CITY OF ALBUQUERQUE

March 9, 2017

**Re: Guardian Storage- Work Order
Erosion and Sediment Control Plan
Engineer's Stamp Date 3-8-17 (A11E015)**

Erosion Sediment Control Plan

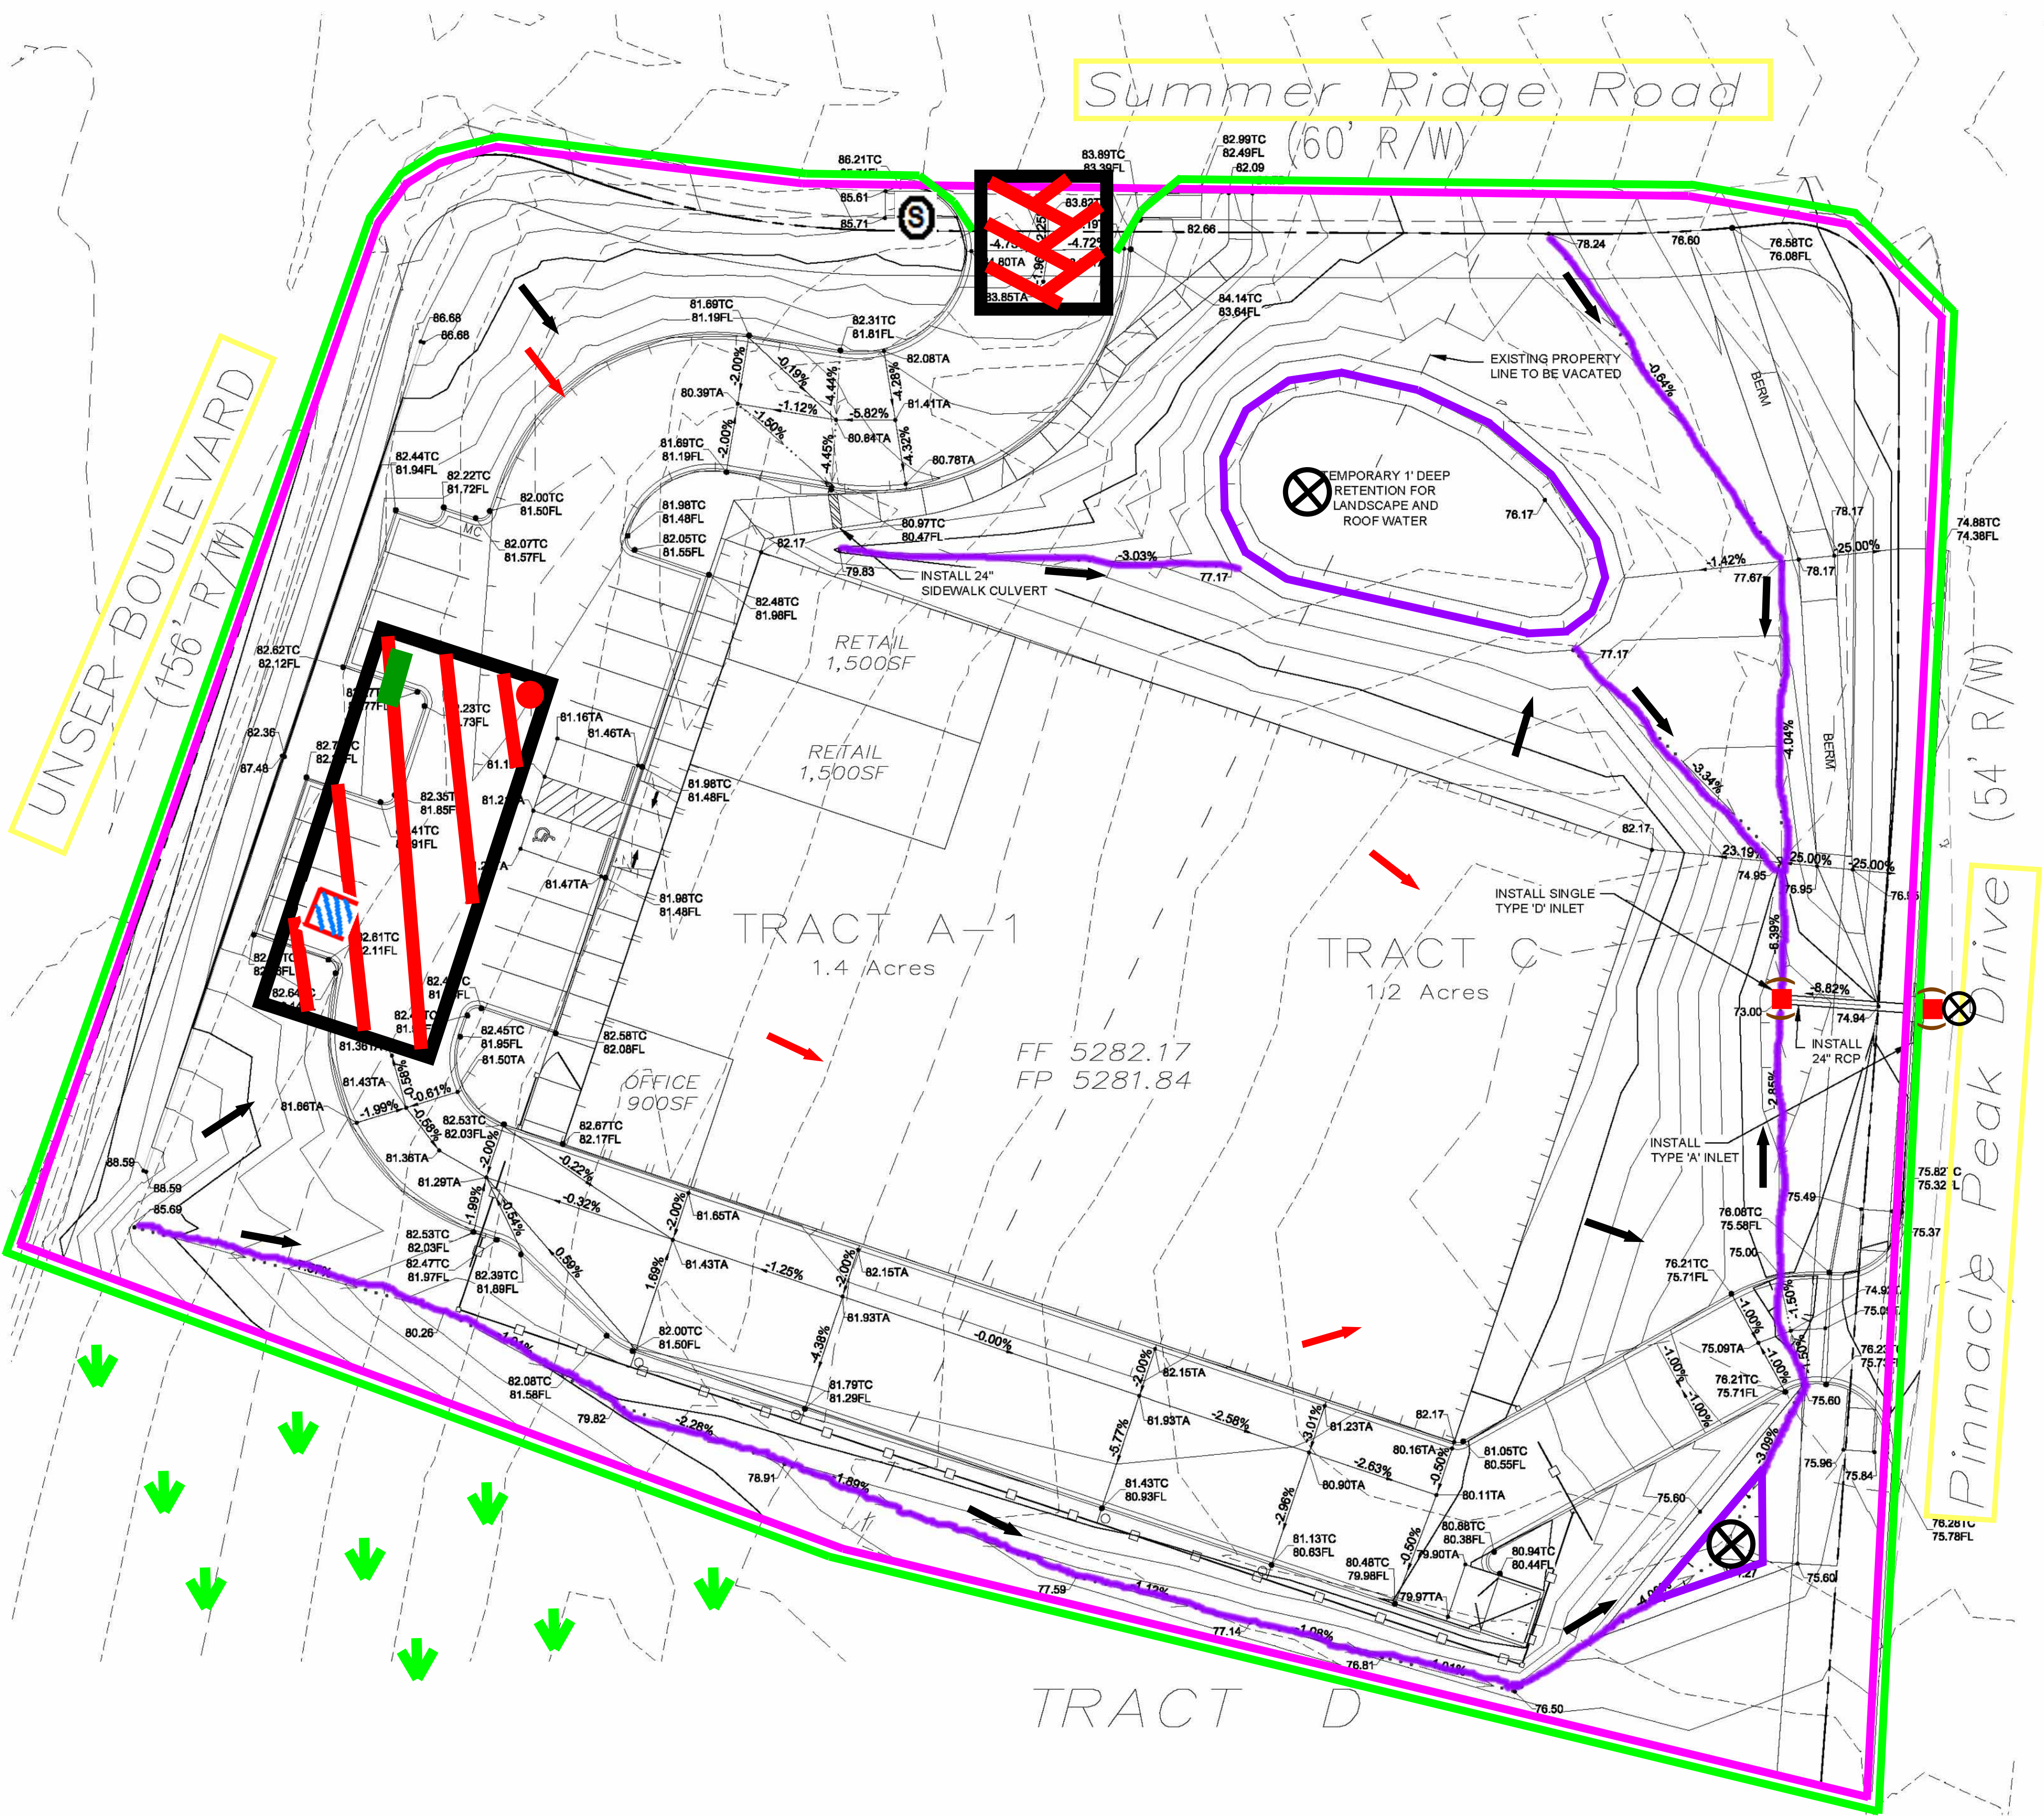
1. Concerning the BMP "Saw Cut and/or Mulch Sock", it is not obvious that a saw cut will work in a street due to the amount of flow and the slope of the street.
